**SOIL/SITE EVALUATION
 for ON-SITE WASTEWATER SYSTEM**

PROPOSED SUBSURFACE WASTE DISPOSAL SYSTEM DETAIL SHEET

SUBDIVISION Hunters Point

LOT 16

HUNTERS POINT
LOTS 16 & 17
PROPOSED SEPTIC

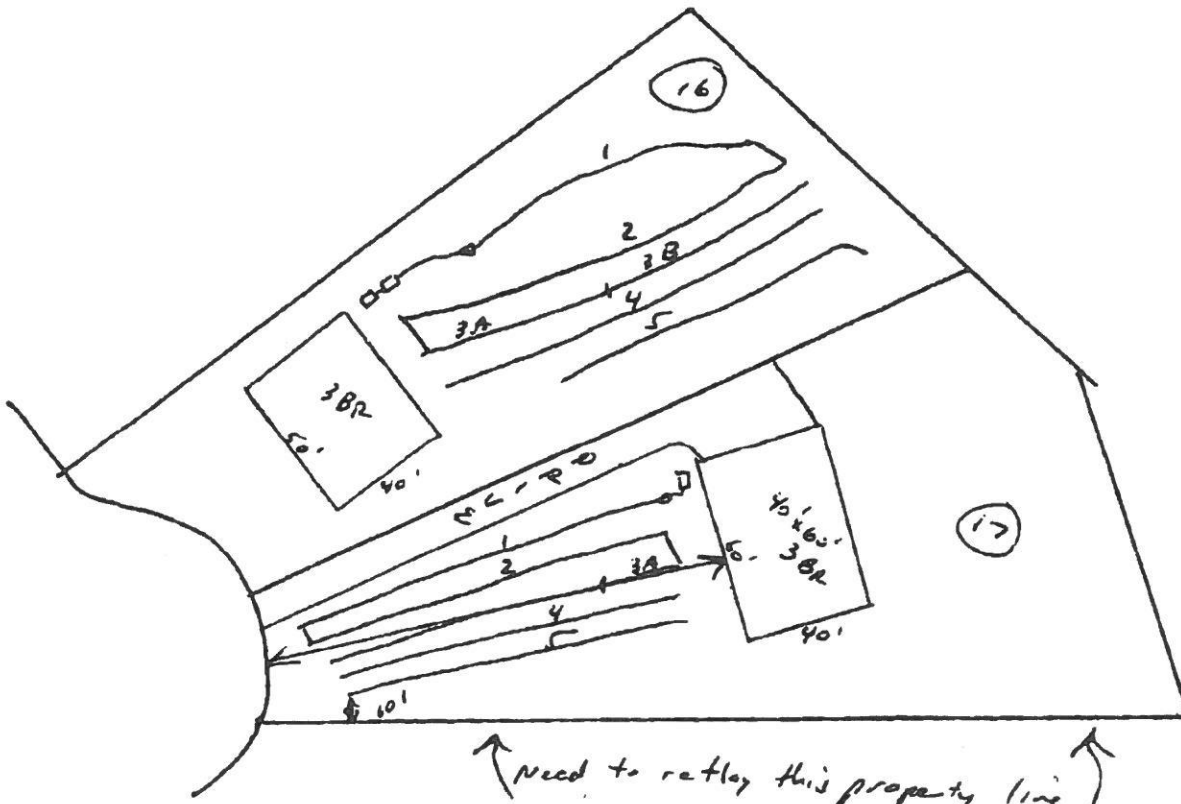
- ① Lot 16 should be approved as you previously submitted
- ② Lot 17 needs to be revised with a 142' house setback. You will also need to reflag lower property line (as shown) to verify location. It may need to be slightly adjusted to maintain 10 ft. Please submit new plot to HARN Co.
- ③ I have met Oliver (HARNER CO) on site and received approval for these designs.
